Change of use of workshop (B1 Businesses) to residential use as a holiday let (C3 Dwelling House)

Rear of Denewood 74 Woodlands Avenue Rustington

Thank you for your internet representation made on 21st July 2013 which has been recorded as '**an objection**' with the comments as follows:

BLOCK/SITE
PLAN

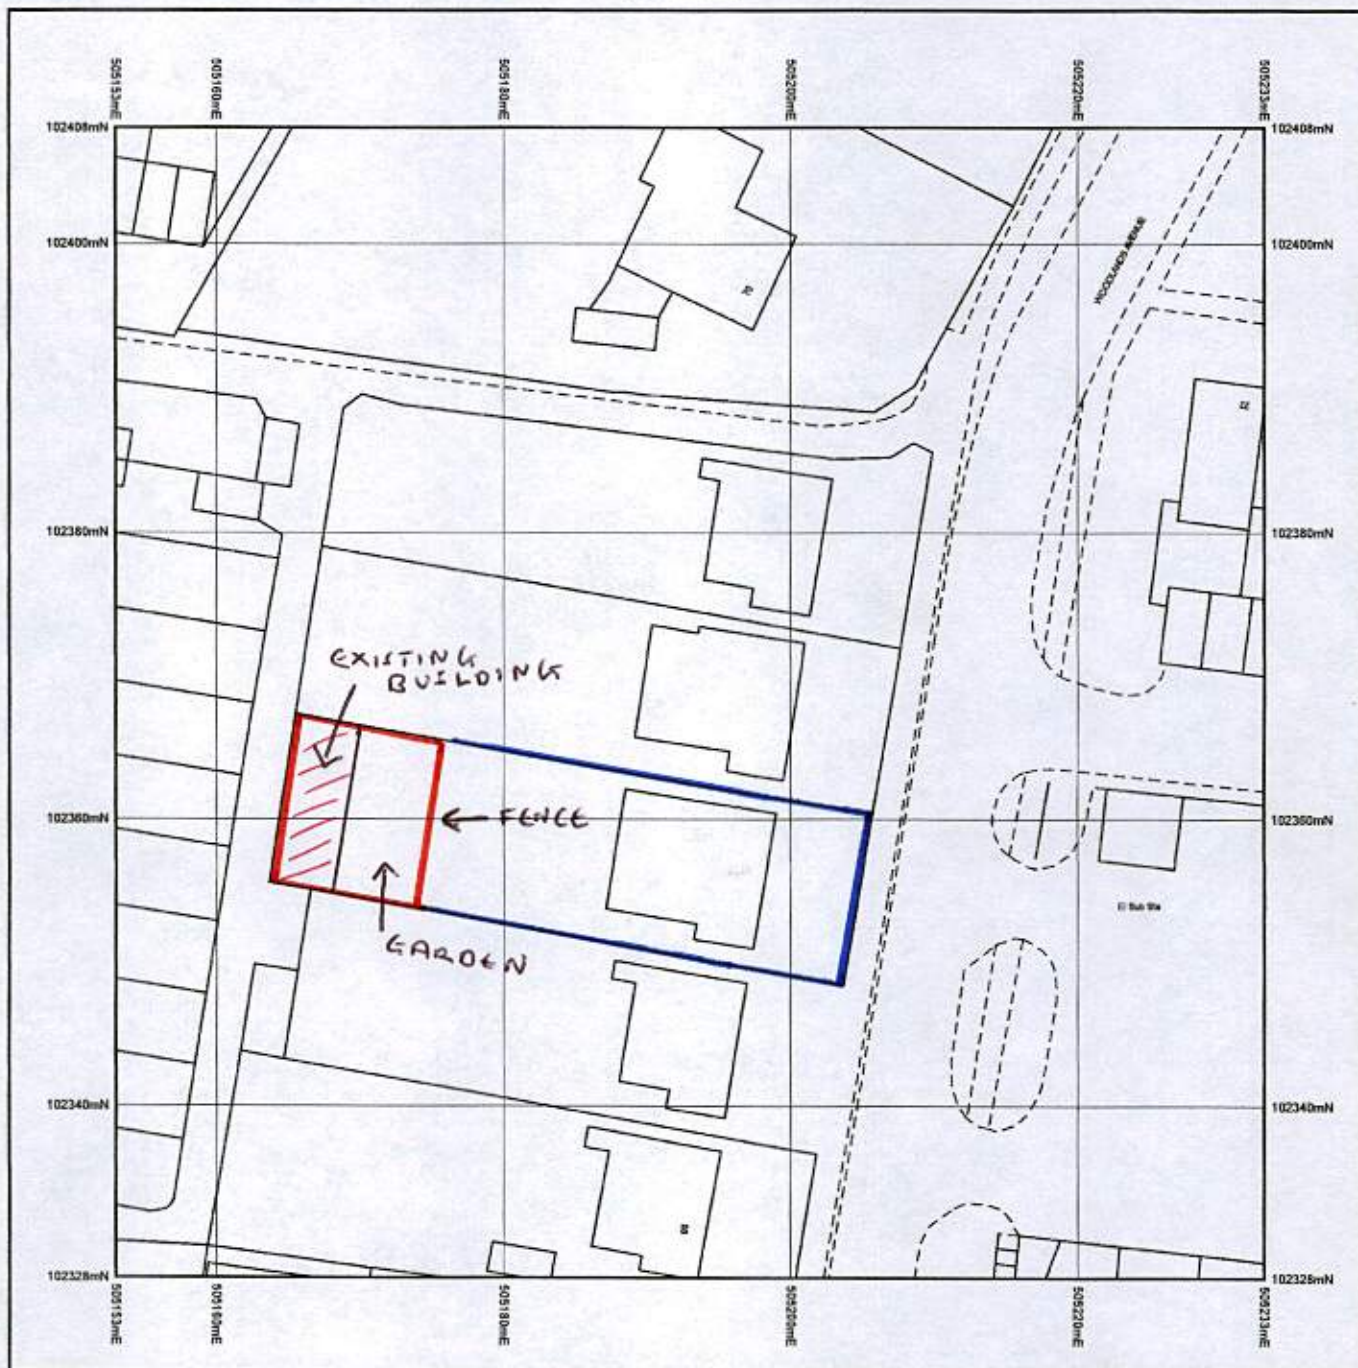
The parking is certainly not adequate for such a busy and multi-functional place. A great strain would be placed on parking by having residents in Denewood itself as well as the existing business and proposed new one. May I point out that the Block Site Plan is incorrectly filled in ?

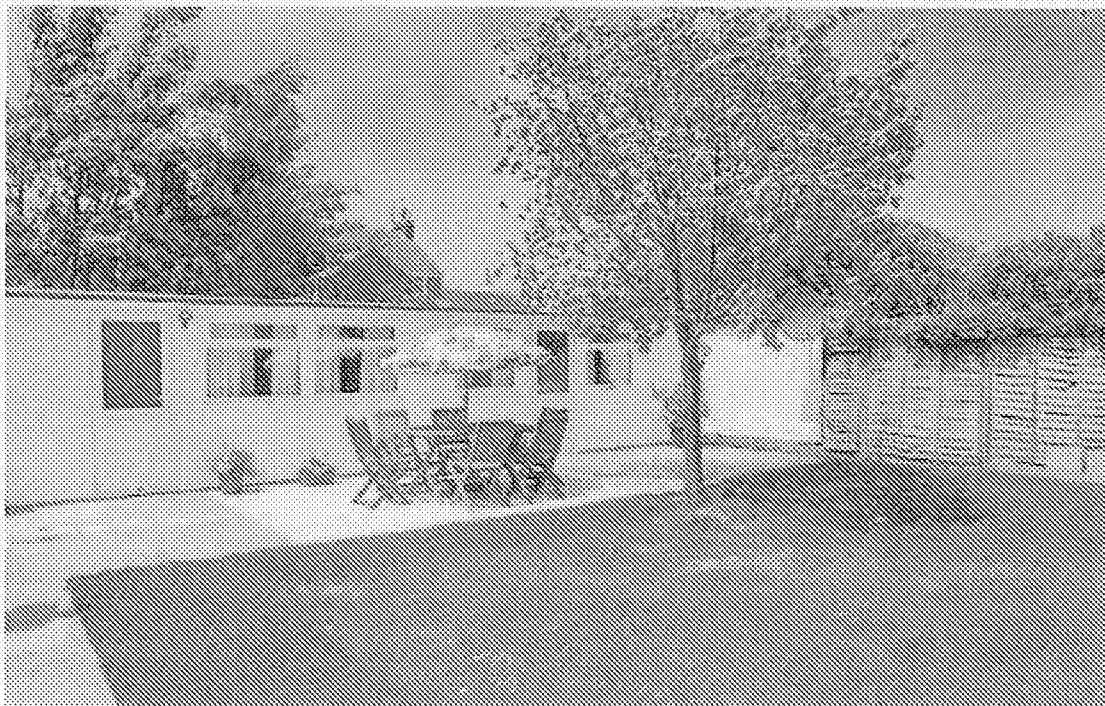
The rear wall of the holiday let building is 3 METRES and 18 CMS from my garden fence, which I find totally unacceptable. Any holiday makers, although nothing to do with me, would be too near !
